Response to Submissions

State Significant Development

New Oran Park High School and
Expansion of Oran Park Public School

Prepared for: NSW Department of Education
September 2017

Figure 5 – Proposed Bus Zone and Drop Off Areas

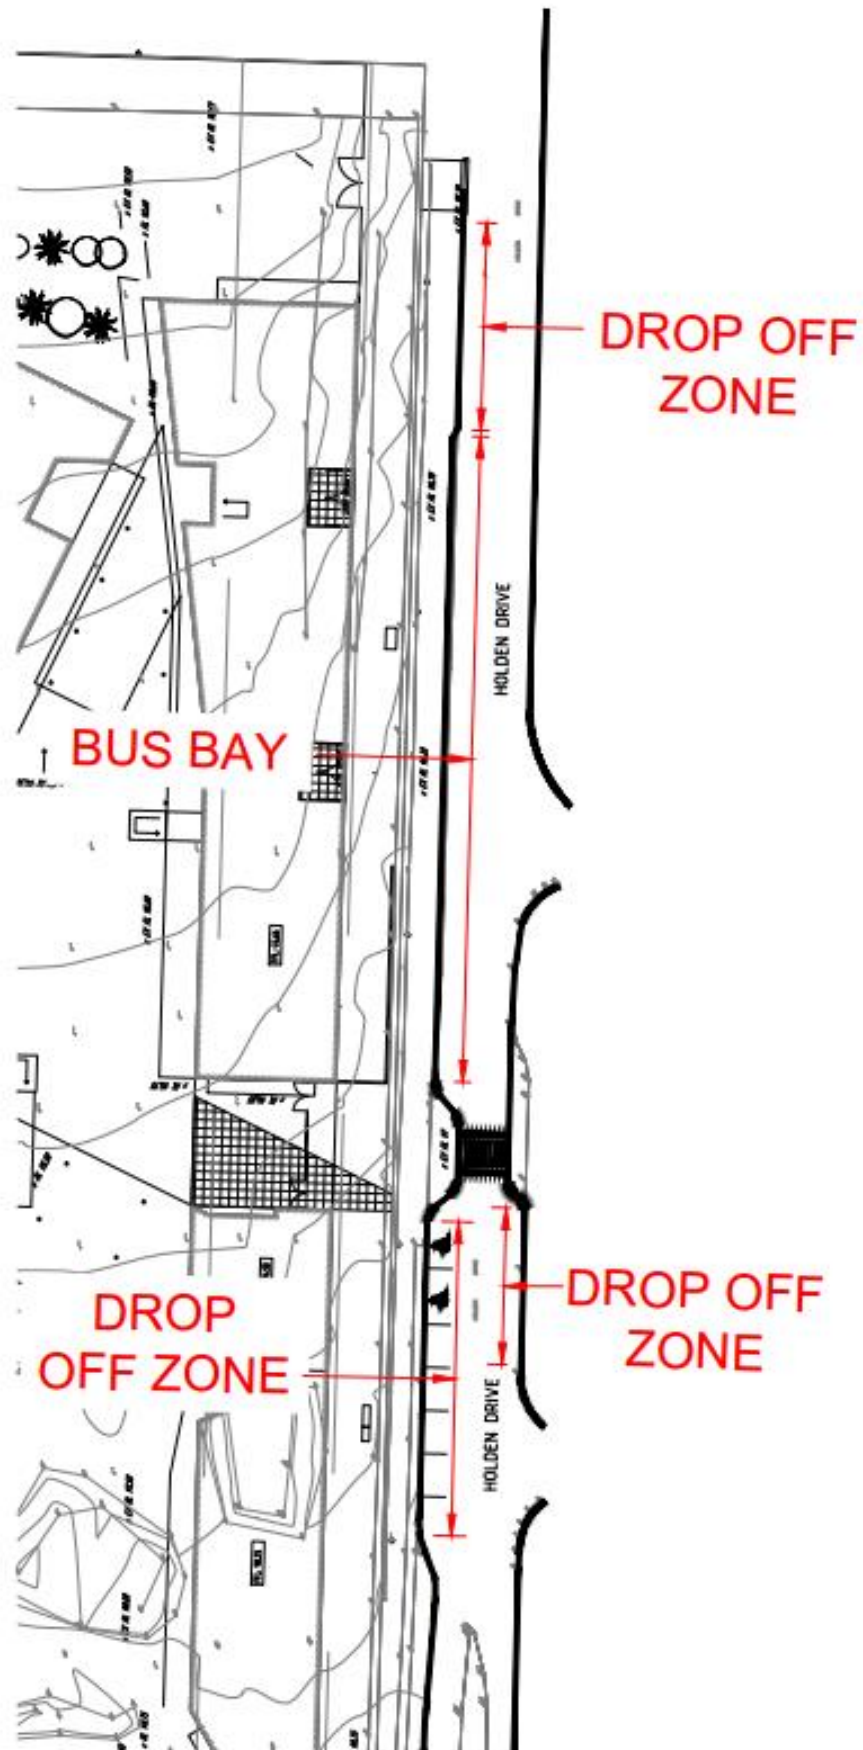
- Landscape Plans (updated) (**Appendix 5**)
- Relocation of Bus Bays
 - Camden Council raised concern in regard to the location of the bus bays on the basis of potential traffic impacts of the 15 busses on the road network.

- Adequacy of Drop-Off Zones
 - Camden Council raised concern in regard to the proposed drop-off zones as they would not accommodate the proposed 400 vehicle drop-off at the AM peak.

- The proposed layout for Holden Drive has been updated to improve traffic flow, including 100m of Bus Zone, sufficient for at least four (4) busses at one time.

- The proposed layout for Holden Drive has been increased to accommodate 14 vehicles and is sufficient to accommodate the anticipated drop off in the AM peak.
